From: Sarah Burrow <Sarah.Burrow@arun.gov.uk>
Sent: 06 May 2021 11:21
To: Planning.Responses <Planning.Responses@arun.gov.uk>
Cc: Simon Davis <Simon.Davis@arun.gov.uk>; Paul Cann <Paul.Cann@arun.gov.uk>
Subject: RE: Planning Consultation on: FP/80/21/DOC

Engineers Comments Regarding Surface Water Drainage

Application No: FP/80/21/DOC
Registered: 31st March 2021
Site Address: MOW COTTAGE WORMS LANE FELPHAM
Description of Works: Approval of details reserved by condition imposed under FP/64/19/PL relating to conditions(s) 5 - Surface Water Drainage, 6 - Discharge to Watercourses, 8 - Schedule of Materials, 10 - Decentralised Energy & 14 - Lighting Specifications

| Drawing Number                                                                                                                           | 2106/SK3 |             | Revision<br>- |

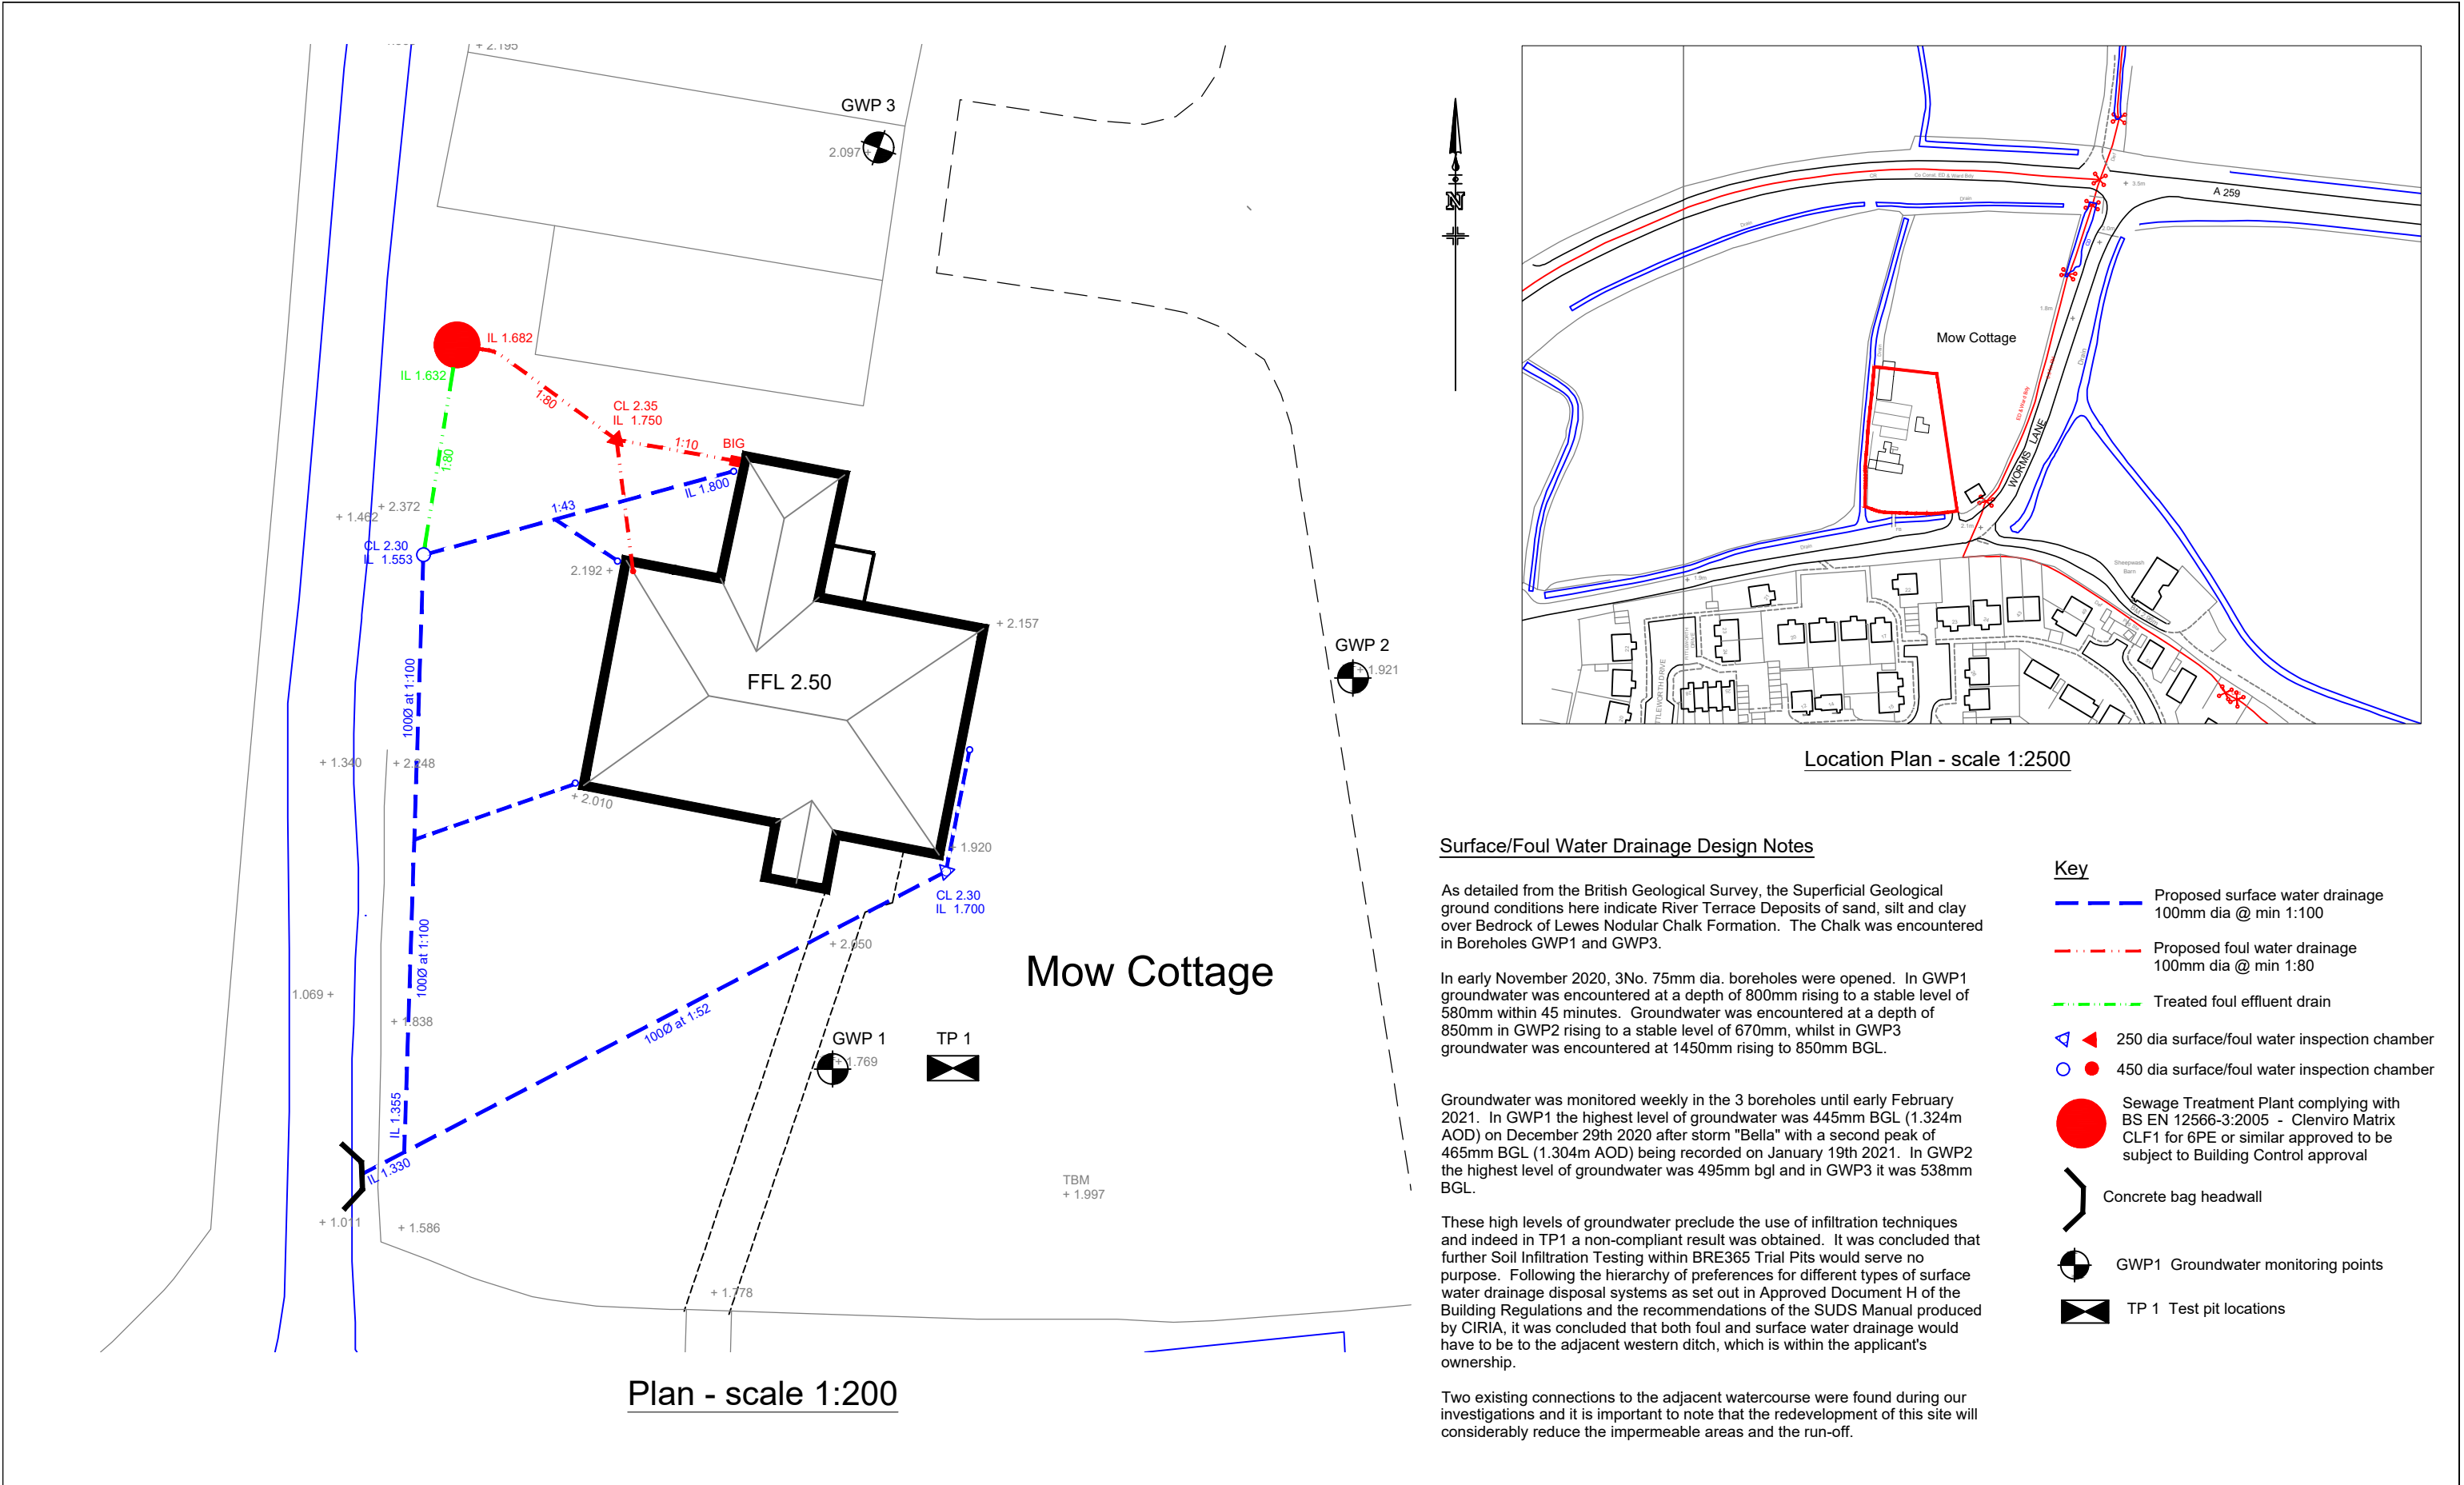
At present there is no effort made to restrict or slow the discharge rate of surface water to the ditch. It is difficult to discern an appropriate discharge rate due to the history of the site. Technically it is fair to consider the site a brownfield site as a house was formerly located there (before the fire in 2006) and it is assumed that there is existing hard standing on site as the design notes state that "redevelopment of this site will considerably reduce the impermeable areas and run off". However, we have no evidence to substantiate this claim, no historic floor plans, no photos, no previous impermeable area plan and no proposed impermeable area plan. If we consider the site as brownfield then policy indicates that we should expect 50% betterment on the existing discharge rates.

In order to better understand the existing system I would expect the pre-development runoff rate calculations to be provided, even if these are to show that the new design will require no restriction of flow due to the reduction in impermeable area.

In addition, even if no storage is required to attenuate flows before a restricted discharge (ie tanks or ponds/basins prior to an orifice or Hydrobrake) then we would still like to see effort made to slow the rate of discharge in other ways. It is suggested that the use of water butts with diverter kits could achieve this to an extent. It is unclear whether a driveway is being introduced for the development, but if so, diverting surface water through lined permeable paving would have the dual benefit of slowing flows and providing water treatment.

1. A sumped manhole provided upstream of the headwall where the pipes connect.
2. If inspection chambers aren't provided on all pipe connections then please include a construction detail drawing for these junctions.
3. A note regarding pipe materials and cover types on inspection chambers/manholes on layout.
4. Please include hard bed, soft bed and top of bank levels on the headwall construction detail drawings.
